EPC STORMWATER REVIEW COMMENTS
IN ORANGE BOXES WITH BLACK TEXT

WALDEN PRESERVE 2 FILING NO. 5 Grading & Erosion Control Plans El Paso County, Colorado

WALDEN PRESERVE 2 - FILING NO. 5

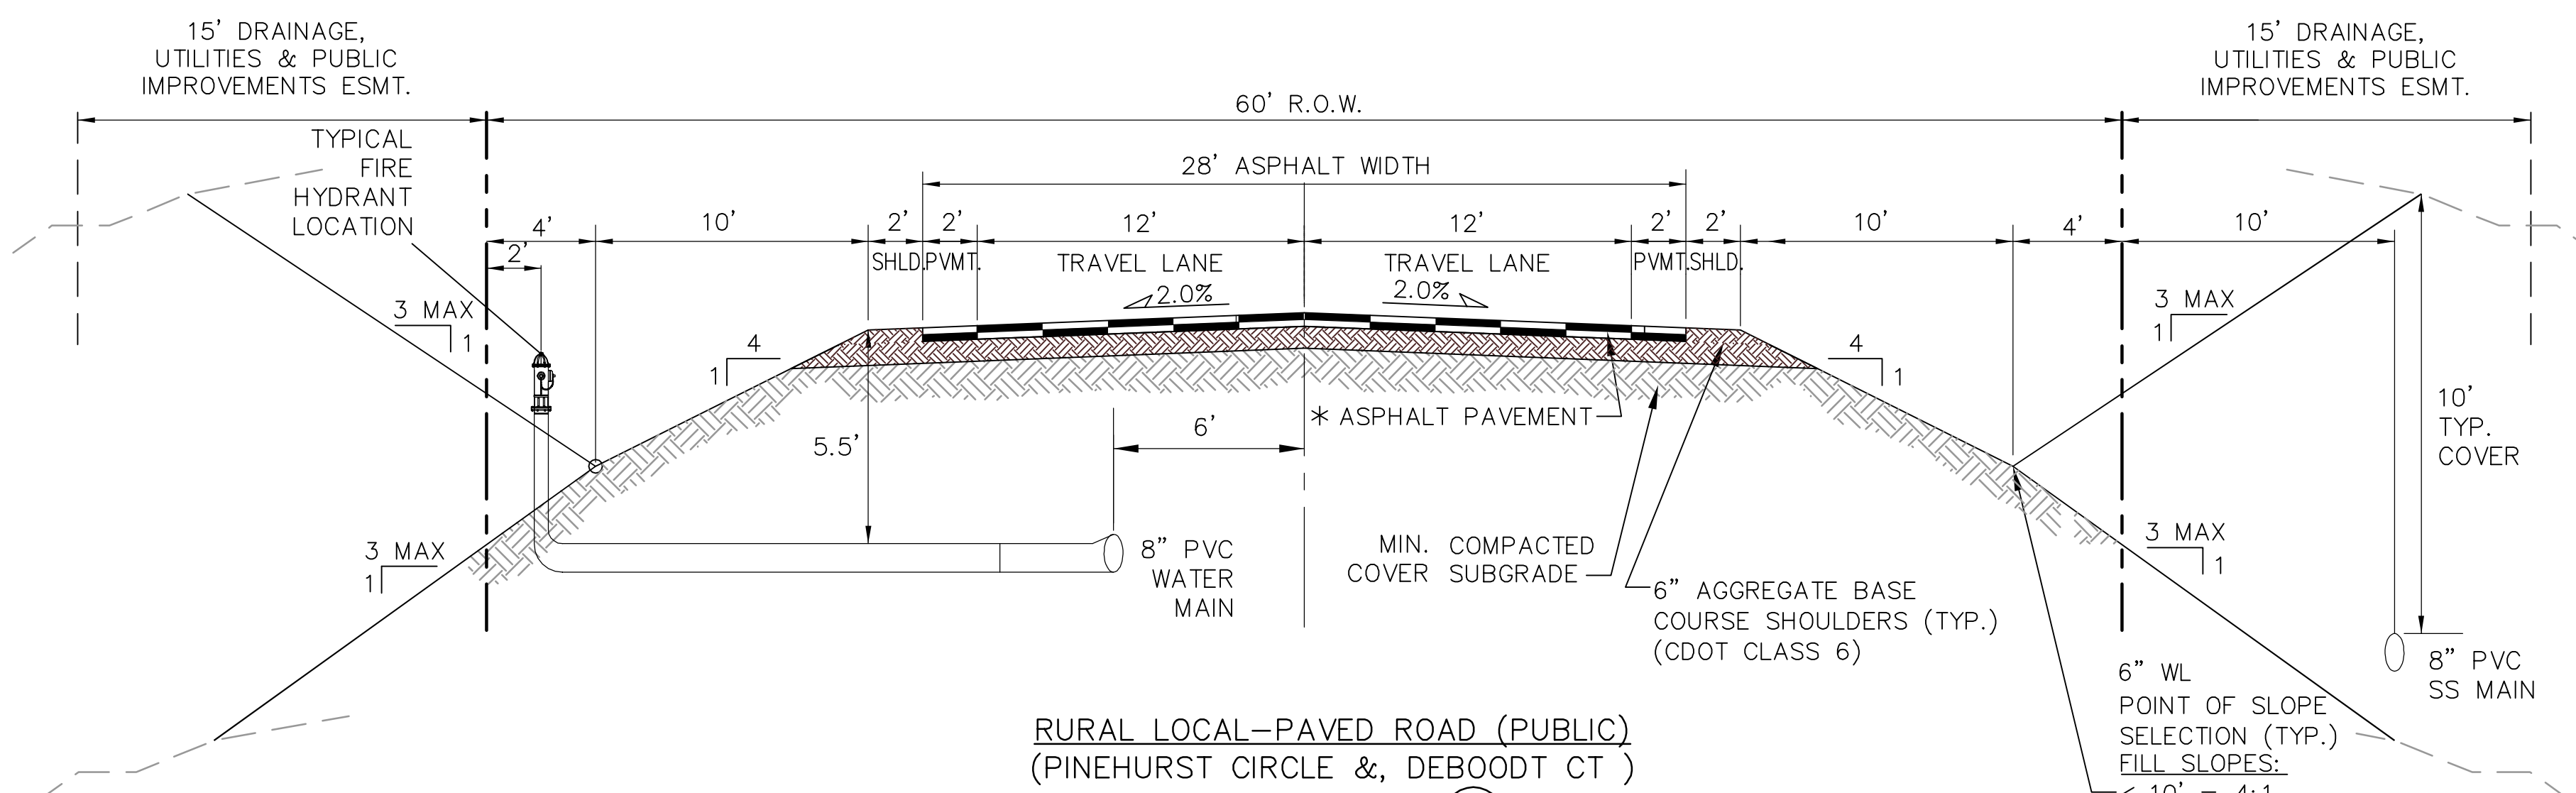
On this overall plan, show limits of sheets C2.1 and C2.2

C:\Users\Michael\Dropbox\jps\projects\040201\walden\dwg\c1\walden_preserve_2\Fig 5\C1.1.dwg Jul 07, 2022 5:08pm

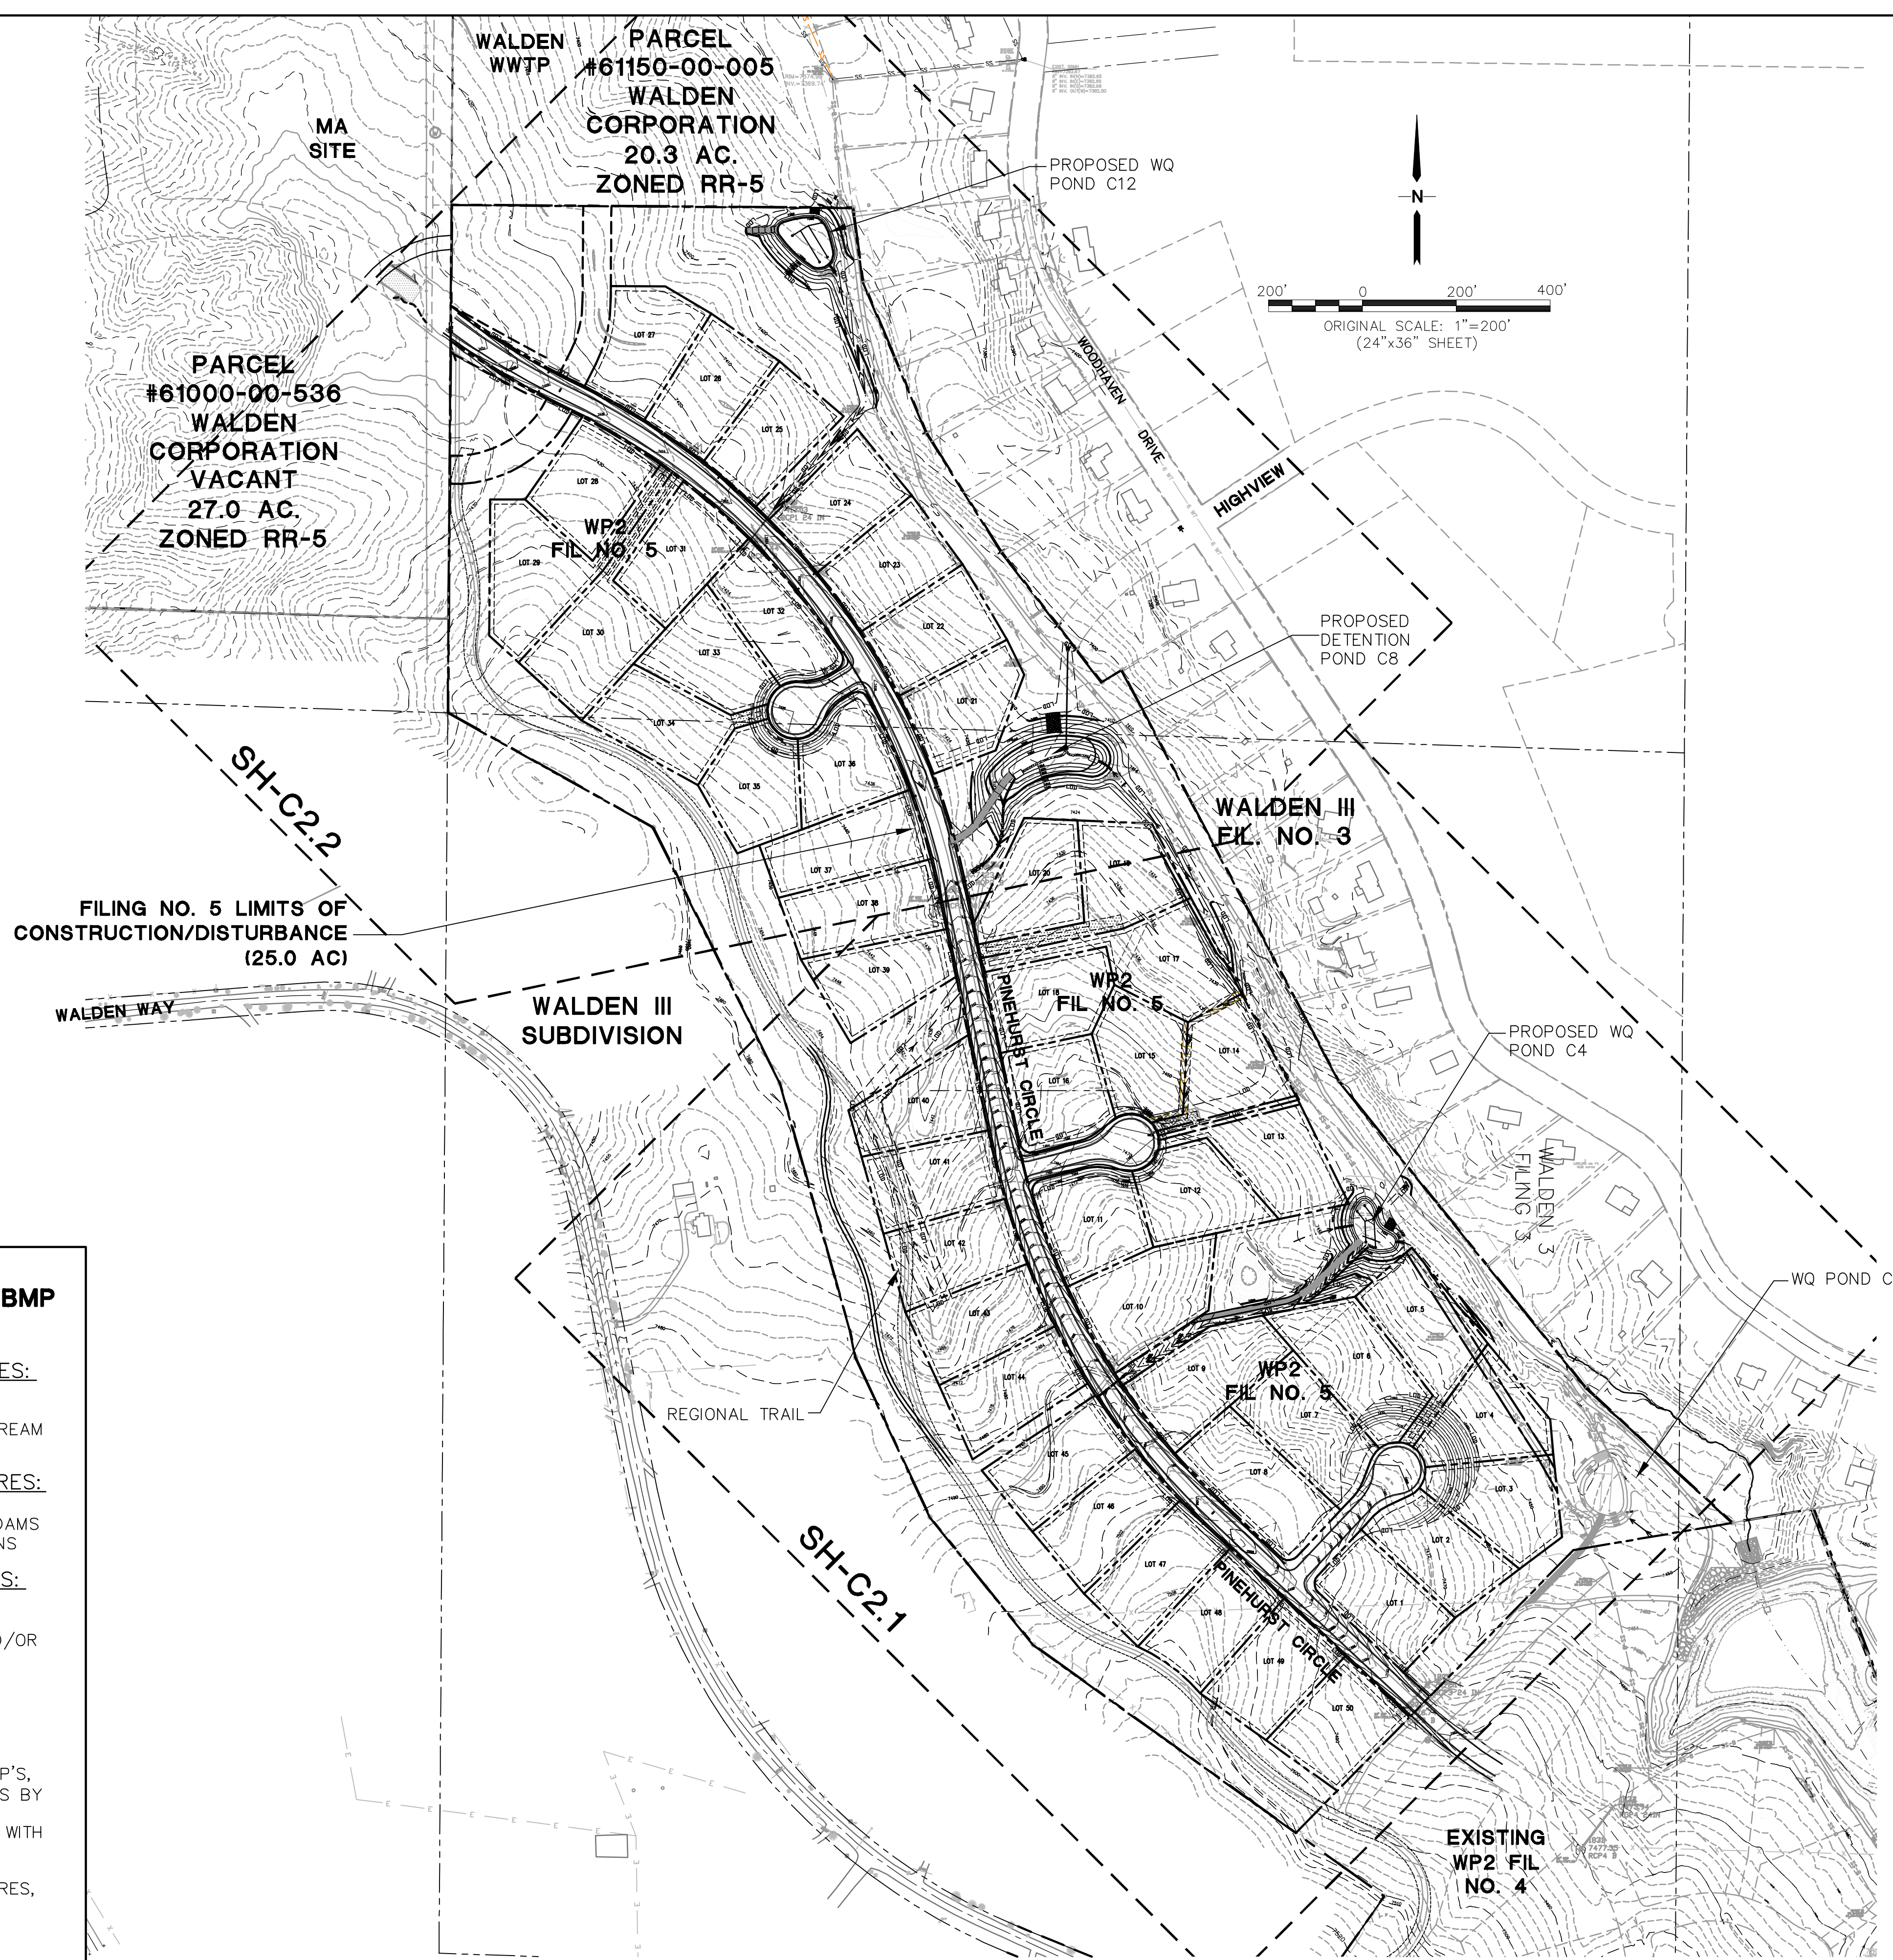
double check. From the drainage map there does not appear to be a significant flow that would warrant a 42" driveway culvert.

C2.1

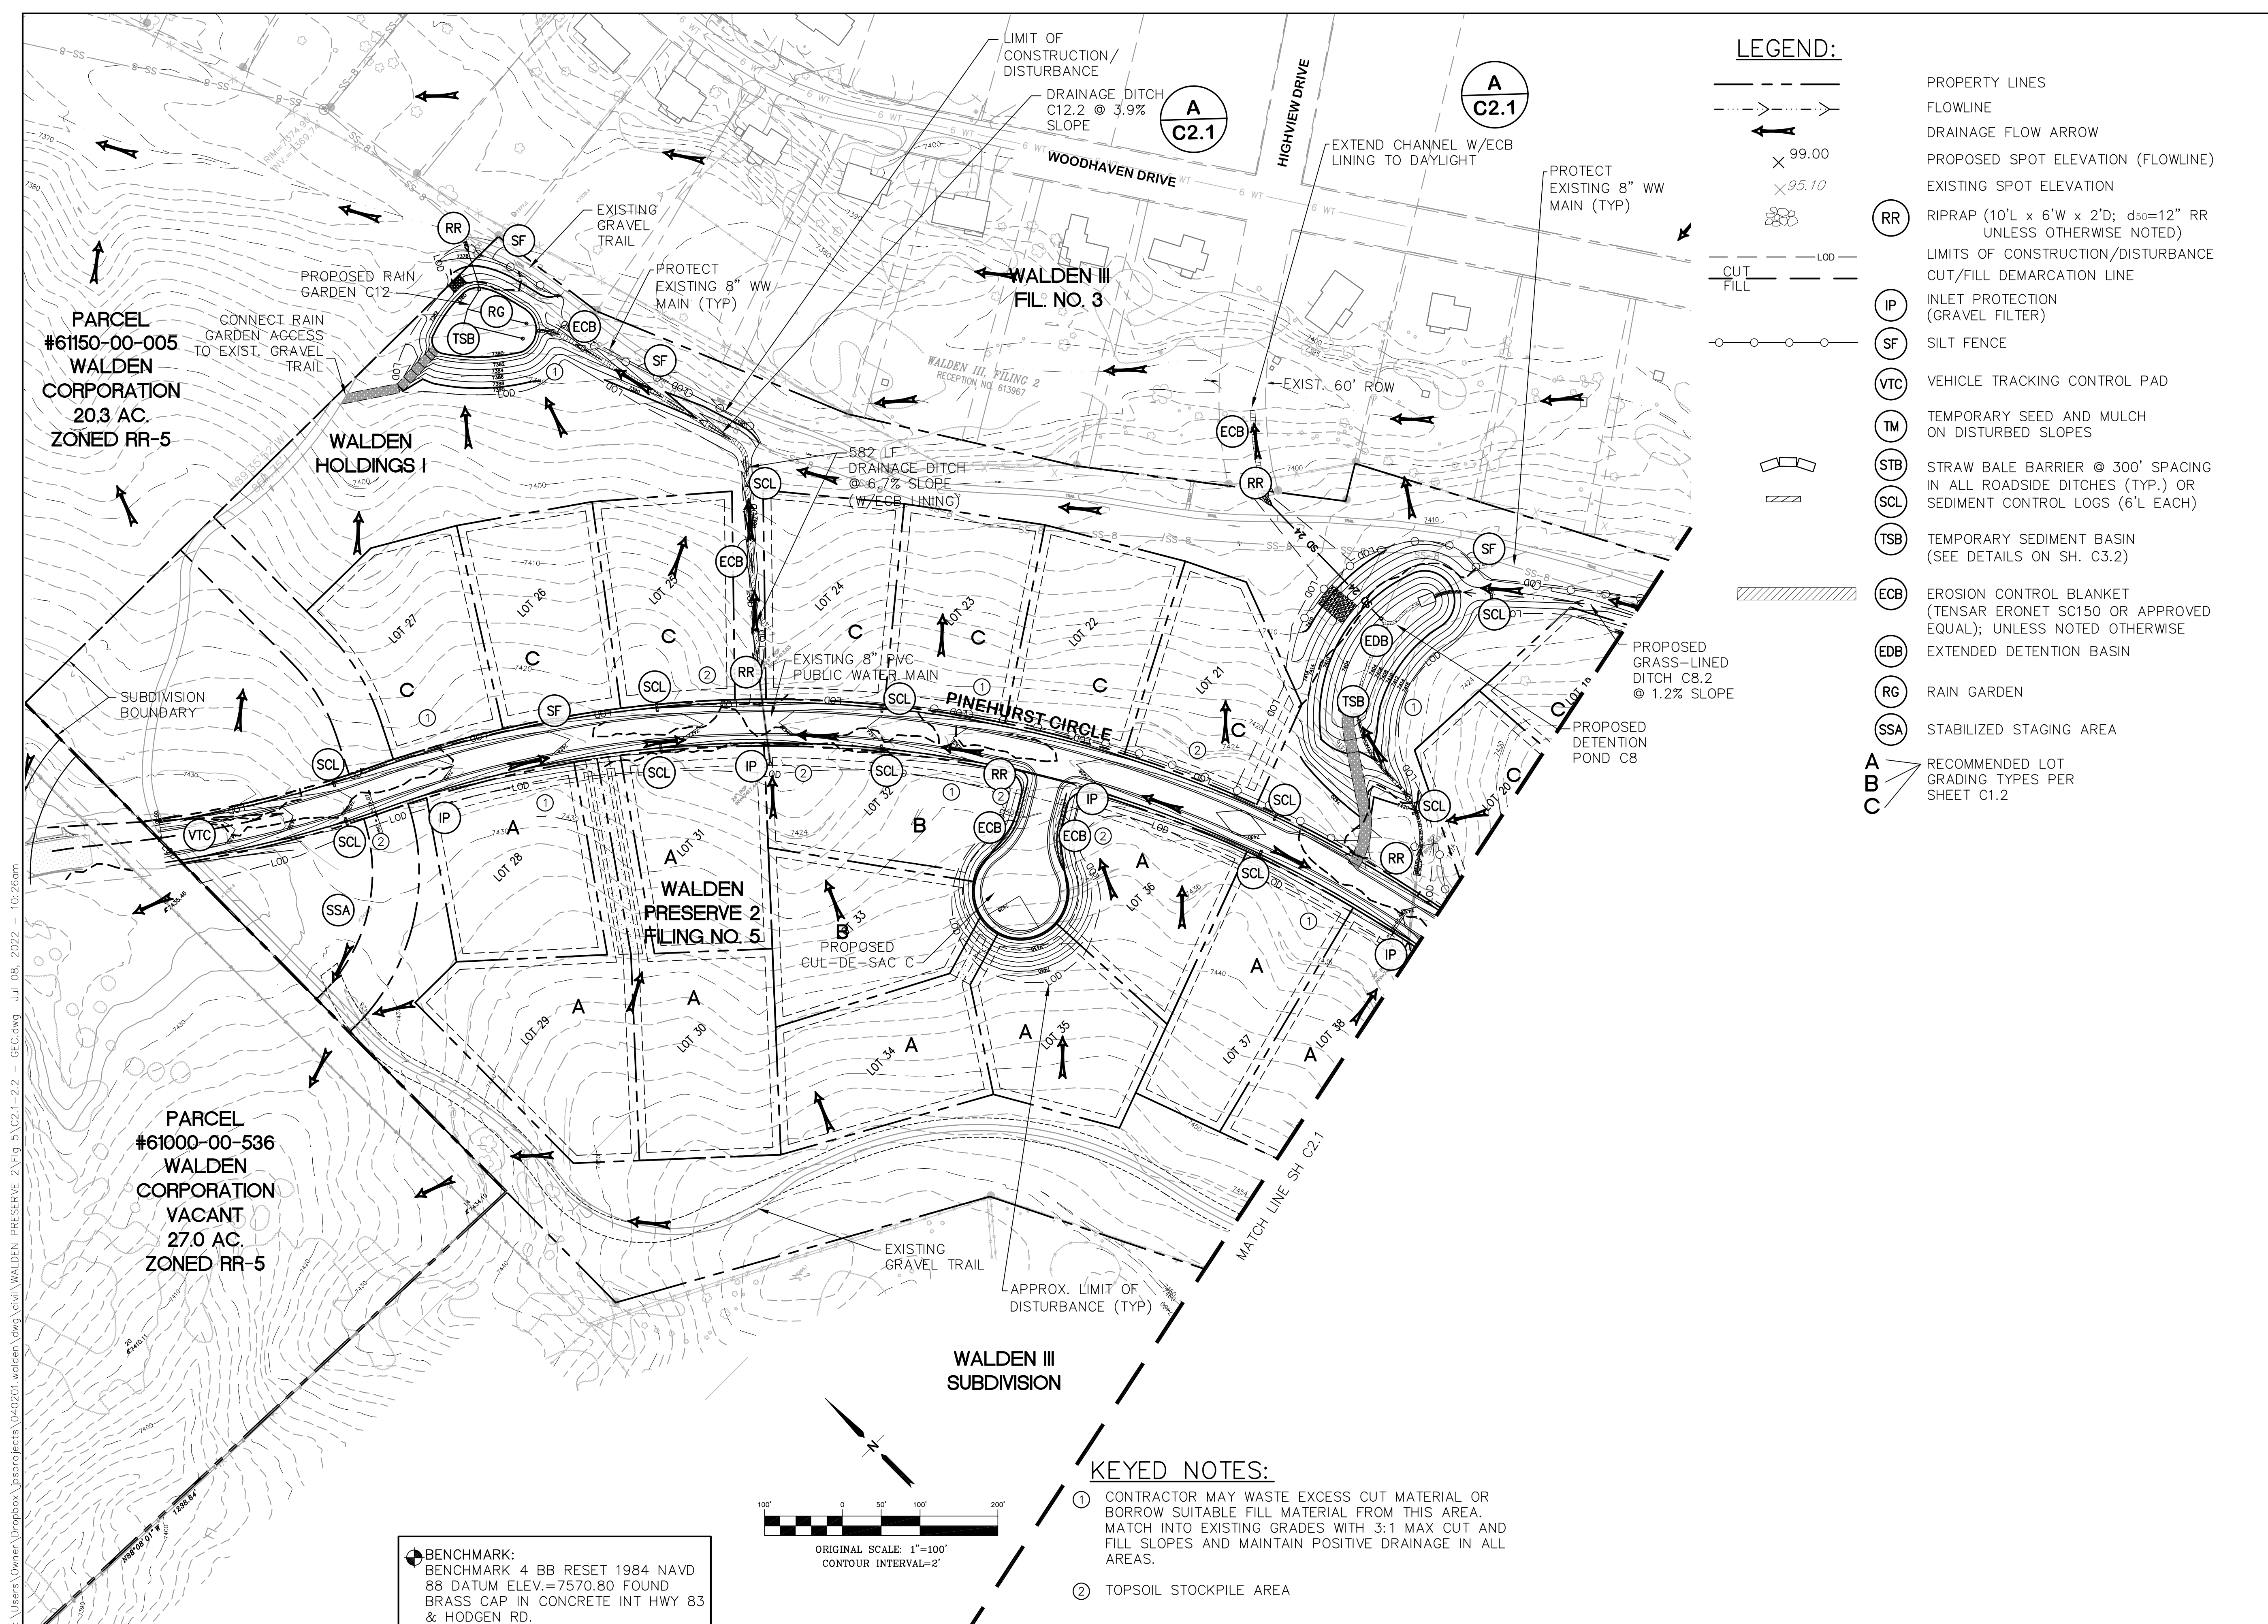
- PROPERTY LINES
 - - - FLOWLINE
 - × 99.00 PROPOSED SPOT ELEVATION (FLOWLINE)
 - × 95.10 EXISTING SPOT ELEVATION
 - RR RIPRAP (10'L x 6'W x 2'D; d₅₀=12" RR UNLESS OTHERWISE NOTED)
 - LIMITS OF DISTURBANCE
 - - - CUT/FILL CUT/FILL DEMARCATION LINE
 - IP INLET PROTECTION (GRAVEL FILTER)
 - SF SILT FENCE
 - VTC VEHICLE TRACKING CONTROL PAD
 - TM TEMPORARY SEED AND MULCH ON DISTURBED SLOPES
 - STB STRAW BALE BARRIER @ 300' SPACING IN ALL ROADSIDE DITCHES (TYP.) OR SEDIMENT CONTROL LOGS (6'L EACH)
 - SCL SEDIMENT CONTROL LOGS (6'L EACH)
 - TSB TEMPORARY SEDIMENT BASIN (SEE DETAILS ON SH. C3.2)
 - ECB EROSION CONTROL BLANKET (TENSAR ERONET SC150 OR APPROVED EQUAL); UNLESS NOTED OTHERWISE
 - EDB EXTENDED DETENTION BASIN
 - RG RAIN GARDEN
 - SSA STABILIZED STAGING AREA
 - A B C RECOMMENDED LOT GRADING TYPES PER SHEET C1.2
- Item S - show drainage flow direction arrows on plans and Legend.

Items H and M. If "limits of disturbance" and "construction boundary" are the same, change to "limits of construction/disturbance" or otherwise show as separate line types for each on the legend and figure.
